31 July 2025

The Secretary
NSW Department of Planning, Housing and Infrastructure

SSD-73910208 Seniors Housing - IRT Woonona Redevelopment

FINAL H.V. CIRCUIT
NOT TO SCALE

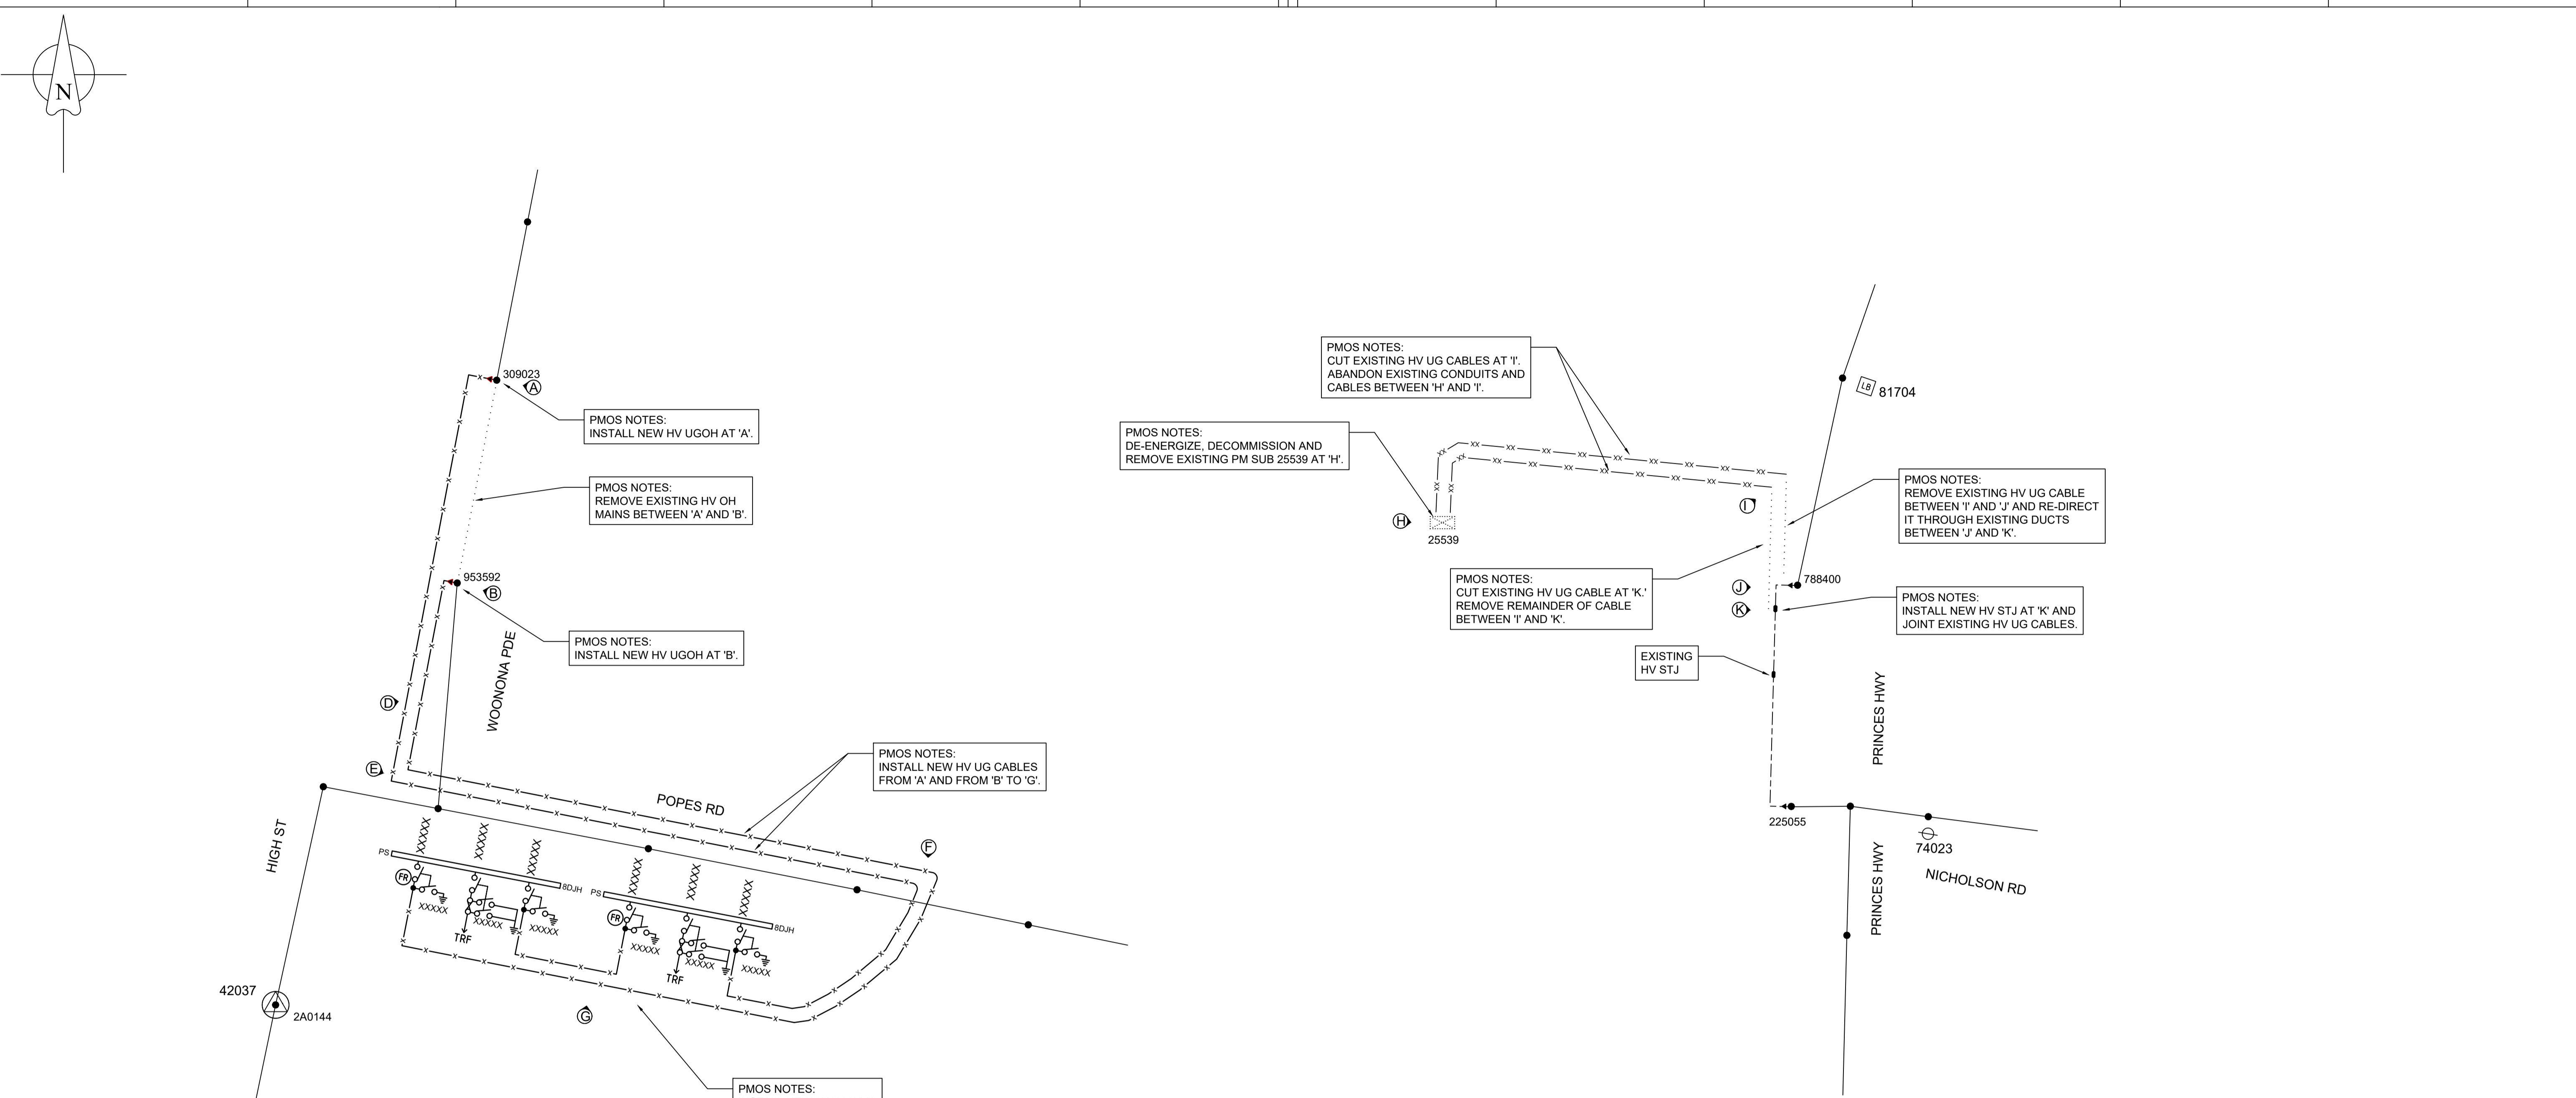
The Environmental Impact Statement does not appear to address the easement for 11,000 volt / 11 kilovolt (kV) high voltage underground cables going to the easement and restriction for fire rating for padmount substation no. 25539 located on the site. These also do not appear to be shown in the Architectural Plans.

The below copy from the Report of 'Photo 5: Substation and HV easements' appears to indicate padmount substation no. 25539 is to be retained in the existing location / easement. However the plan does not appear to correspond with the proposed redevelopment of the site ie. please refer to the below copy of the Ground Floor Plan on which the approximate location of the padmount substation is shown. In addition it includes the following note (which may require an application to Endeavour Energy for a dispensation). Accordingly an alternative 'power supply' may need to be considered?

EXISTING HV CABLES TO BE RELOCATED
FROM UNDERGROUND TO BE ENCASED
WITHIN THE NEW BASEMENT SLAB
